From: Sarah Burrow <Sarah.Burrow@arun.gov.uk>
Sent: 14 February 2020 15:30
To: David Spring <David.Spring@arun.gov.uk>
Cc: Planning.Responses <Planning.Responses@arun.gov.uk>
Subject: RE: Drainage Engineer response - Planning Consultation on: BE/126/19/PL

APPLICATION NO: BE/126/19/PL

Site Address: Land at Phase 1A Oldlands Farm Shripney Road Bognor Regis
PO22 9NN

Description of Works: Erection of a discount convenience retail food store (Use Class A1)
& parking, landscaping & other associated works

AD 110_REV C

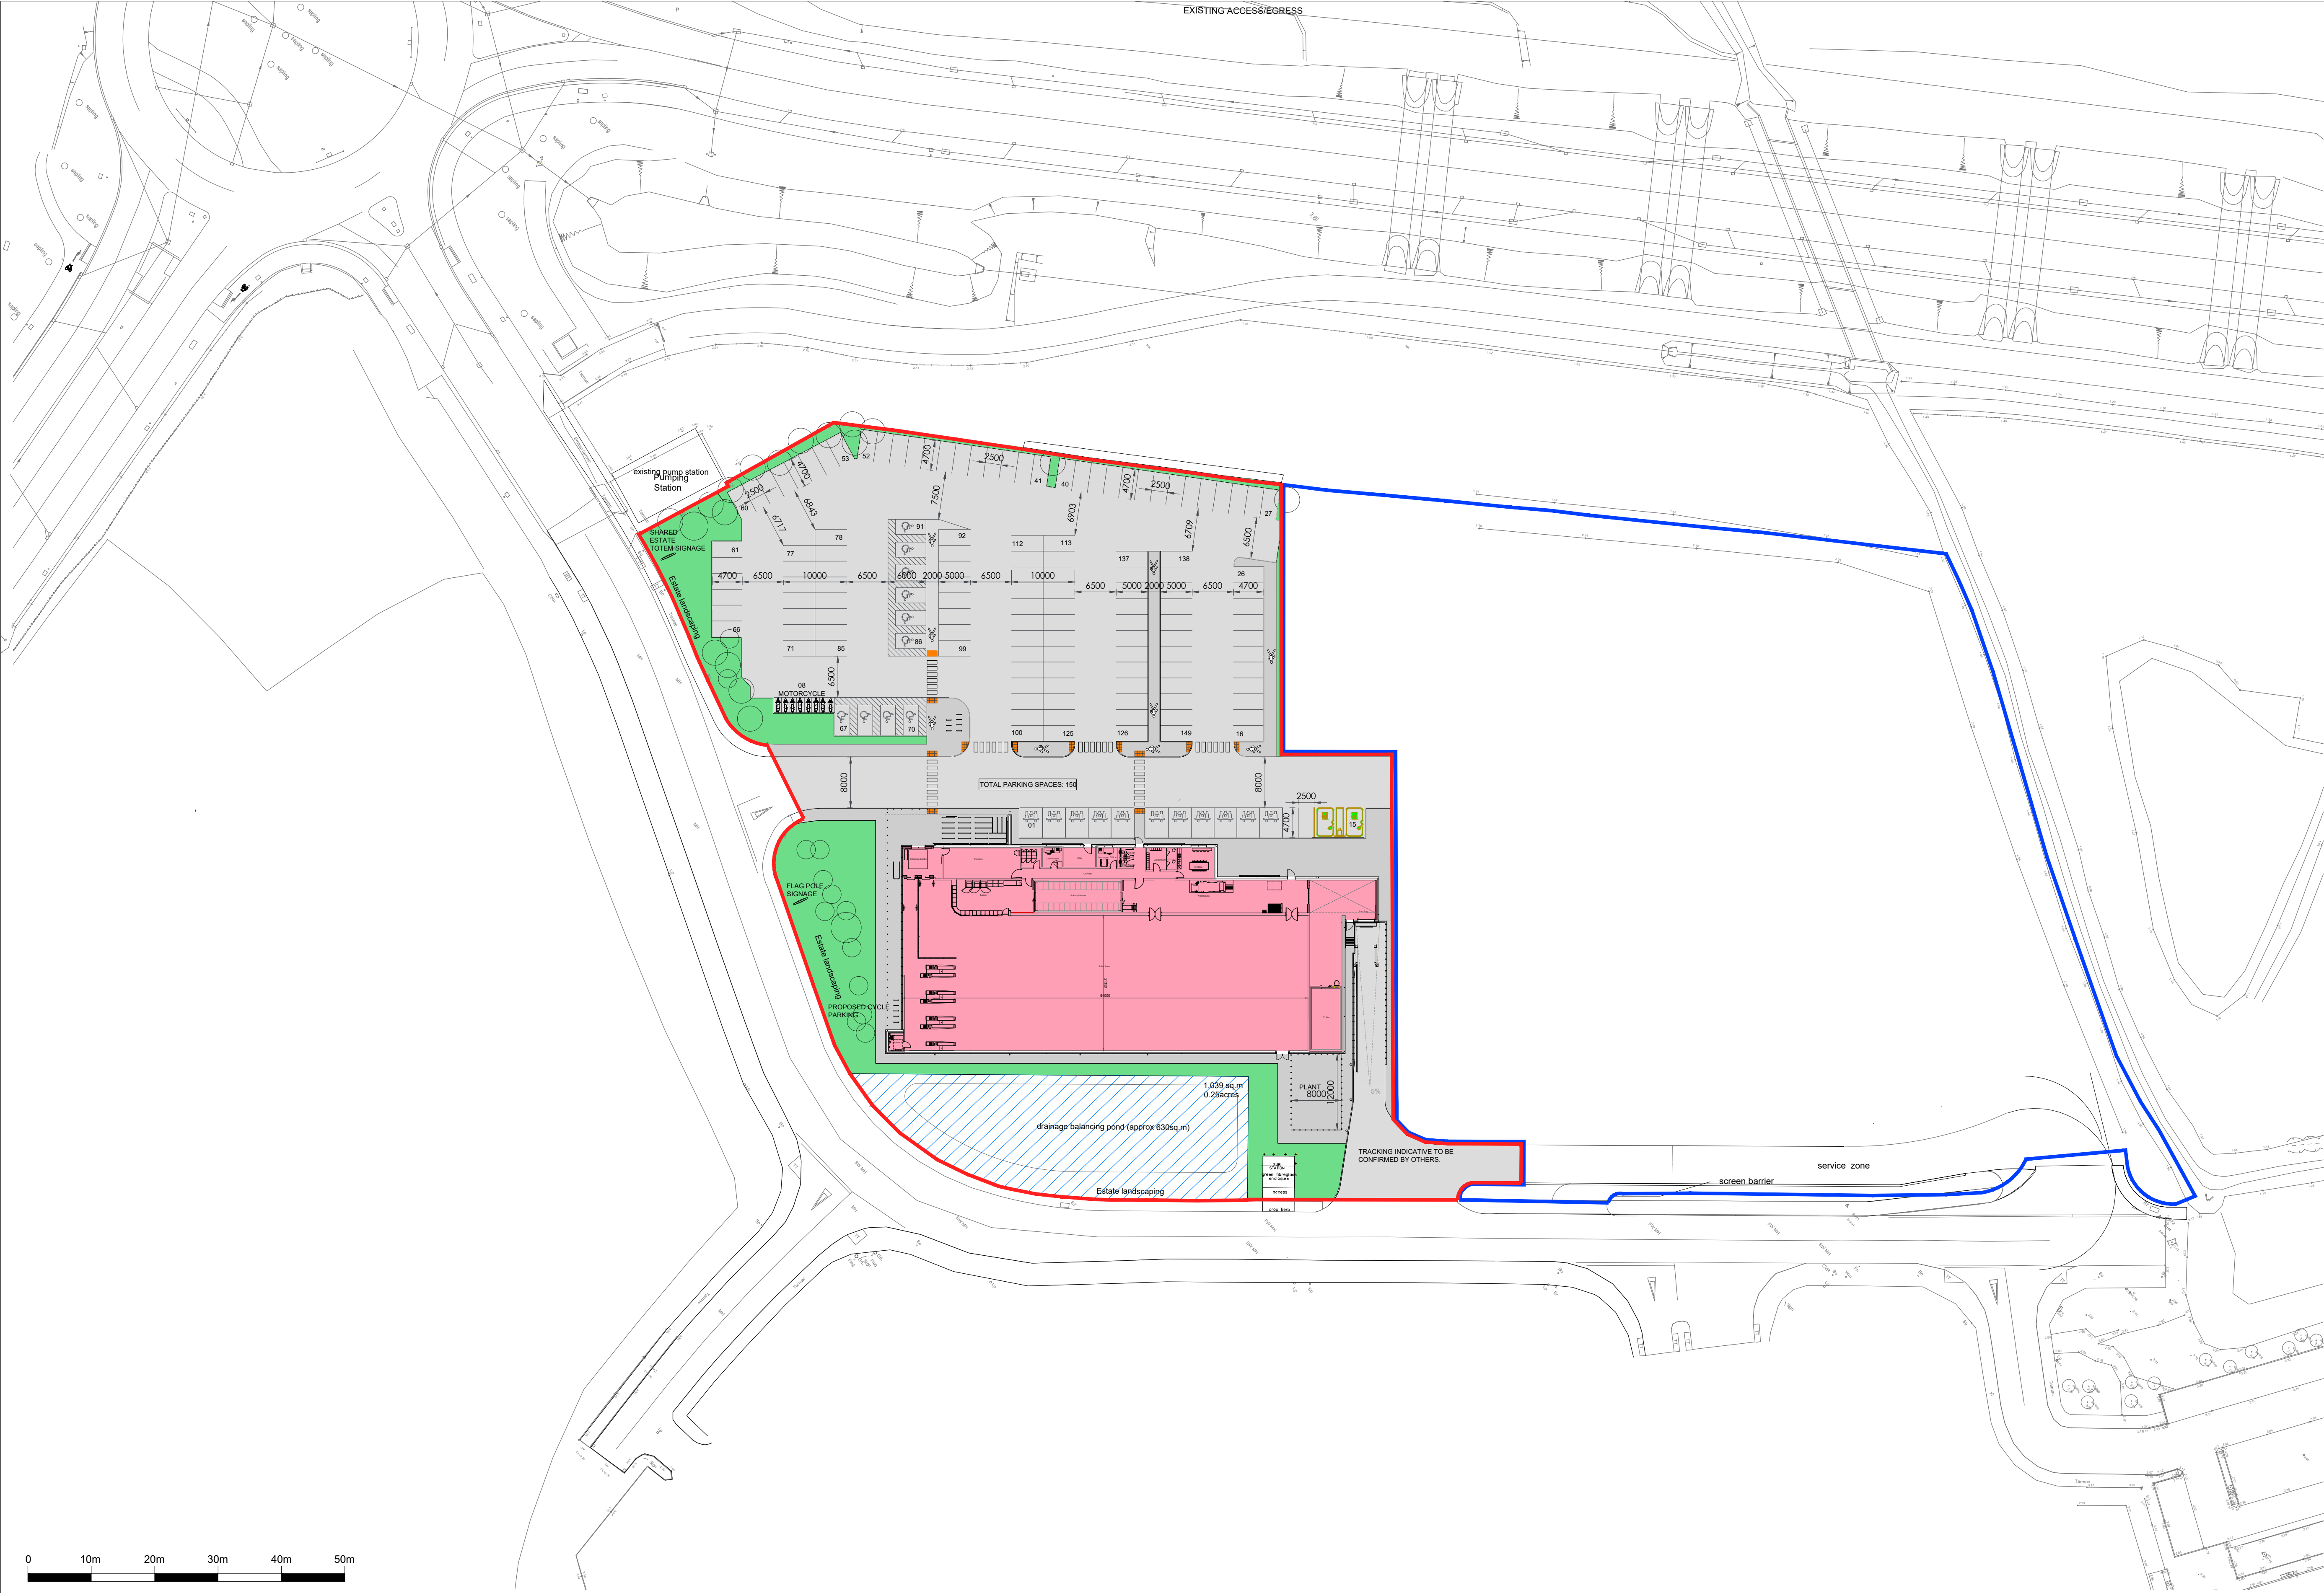
4. We require a 3m easement from the top of the bank of the attenuation basin (on all sides).

4. We require a 3m easement from the top of the bank of the attenuation basin (on all sides).

Noted, we are double checking this and will confirm the 3m easement shortly. Great.

Further to my last email, we also confirm that on point 4 that the proposal fully meets the easement requirements.

Noted, we are double checking this and will confirm the 3m easement shortly.
